A303 Amesbury to Berwick Down

Deadline 7
8.5(1) - Statement of Common Ground –
National Trust

STATEMENT OF COMMON GROUND – National Trust

Version	Date	Status of Version
Rev 0	03.05.2019	Deadline 2 Issue
Rev 1	09.08.2019	Deadline 7 Issue

PROPOSED BORED TUNNEL - (WORK No. 1F)

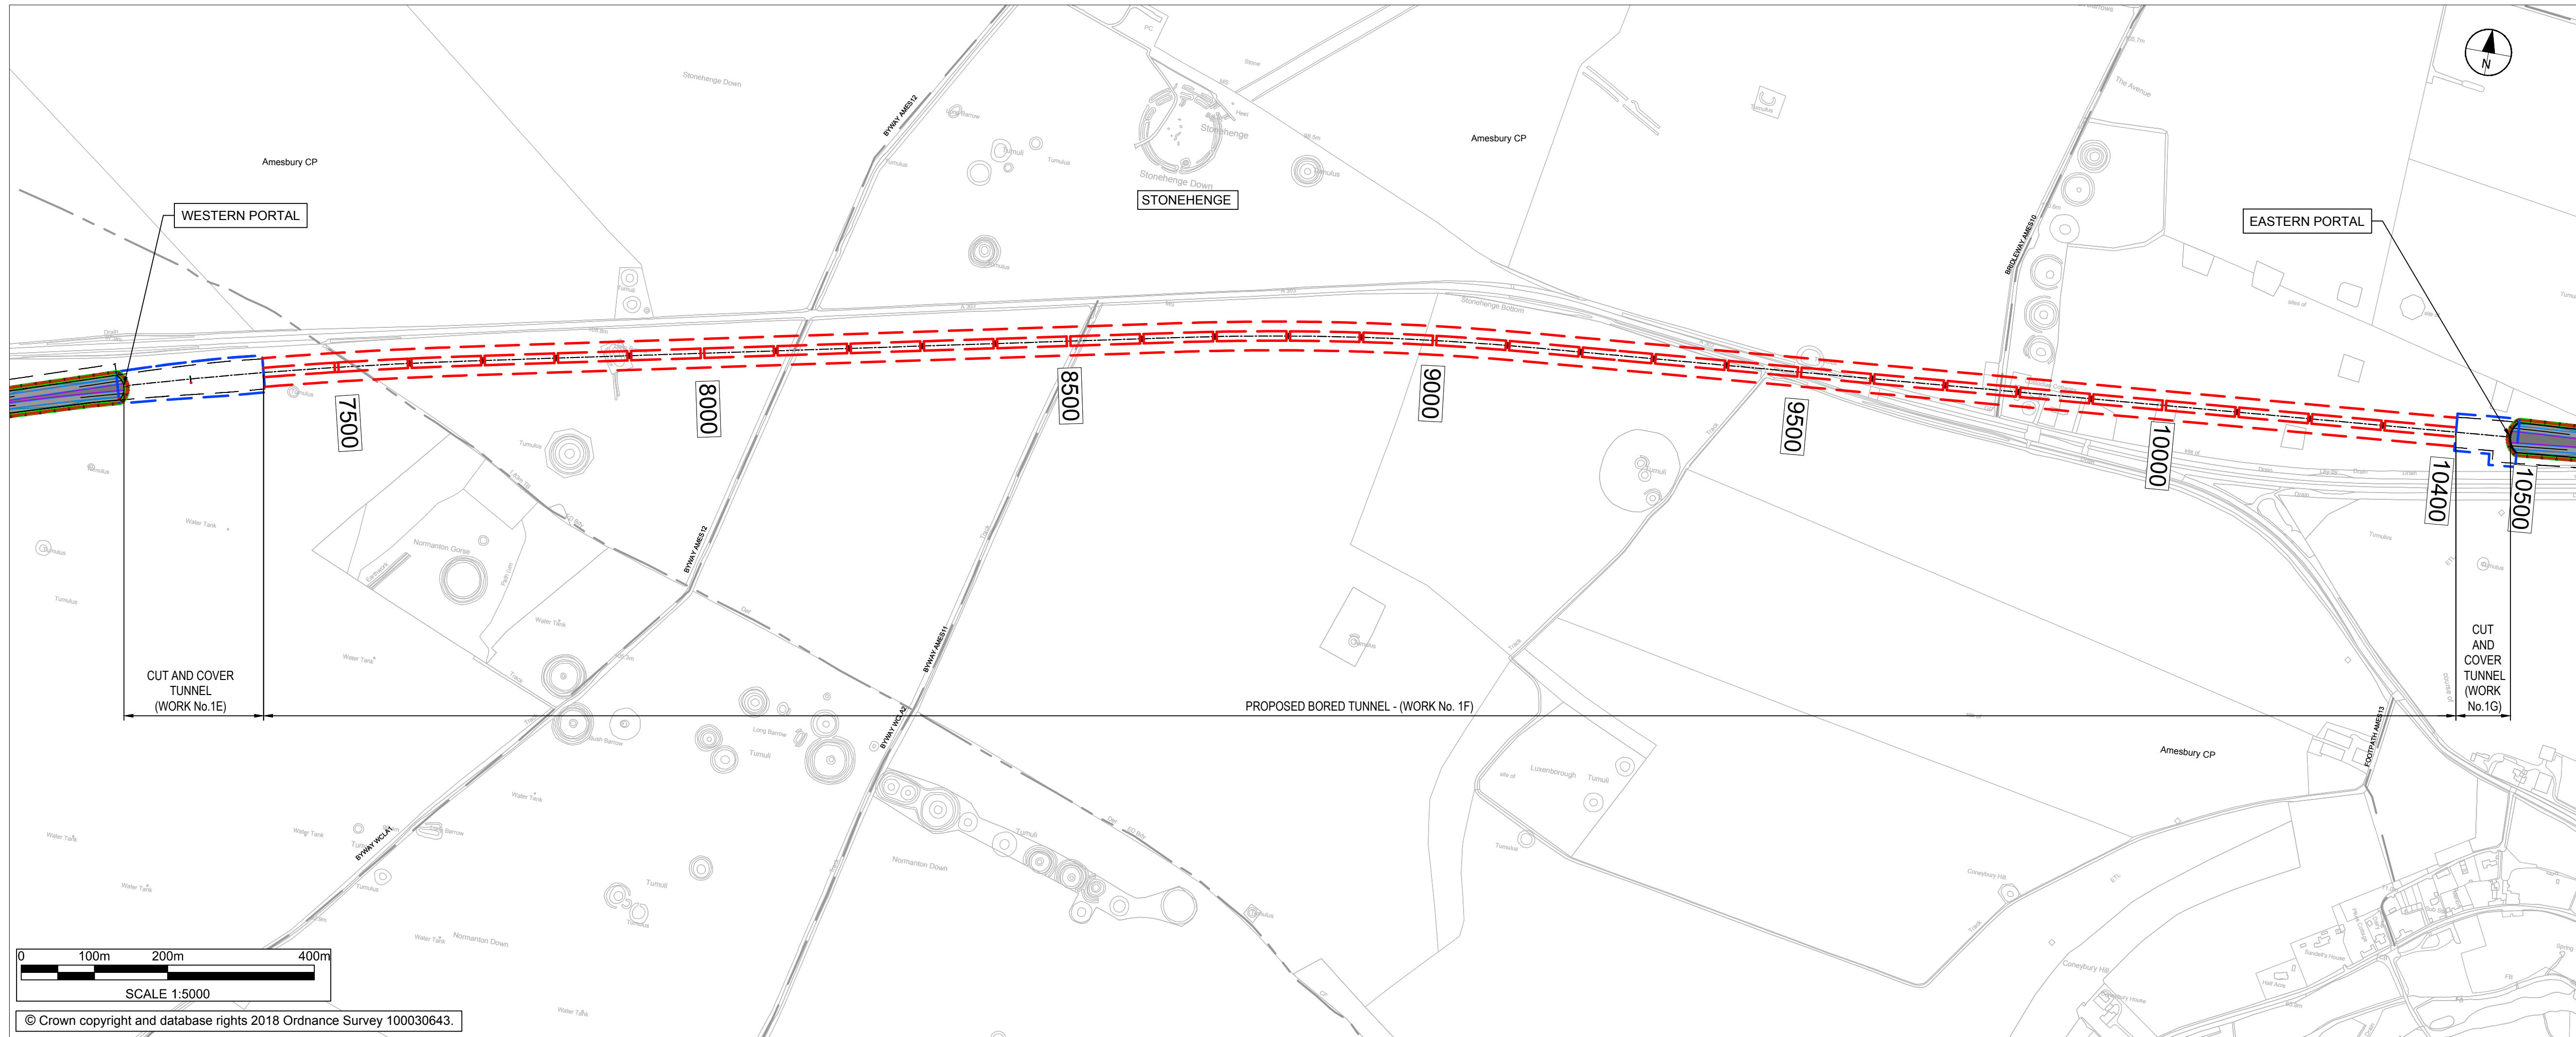
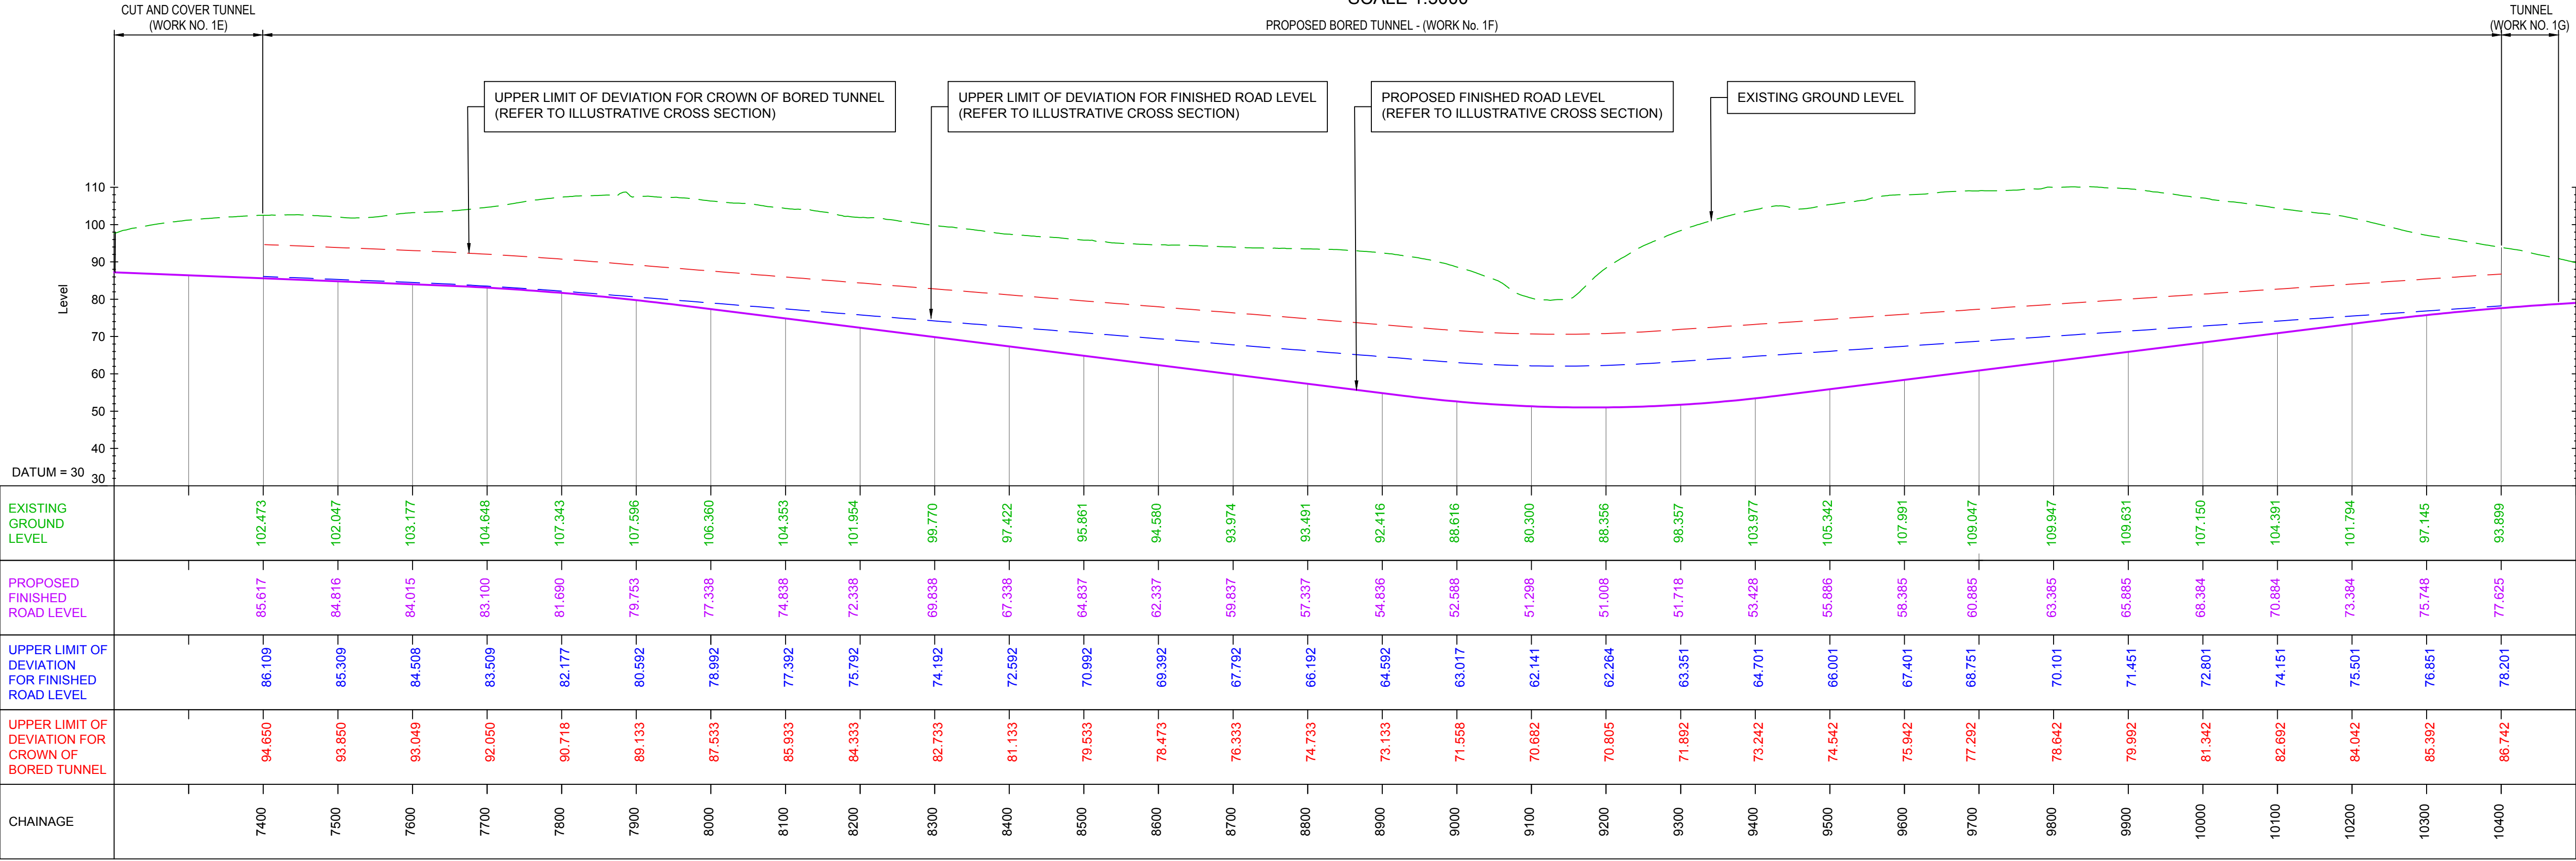
3.10	[RR-2344] WR [REP2-115]	5.1.5 6.8.5	Limits of deviation	<p>The Trust is content with the tunnel LoDs; that the impact of their implementation has been included in the Applicant's assessment work; and that should the LoDs be utilised to any extent, the mitigation measures for this will be appropriately controlled within the provisions of the DAMS.</p>	Agreed	Agreed
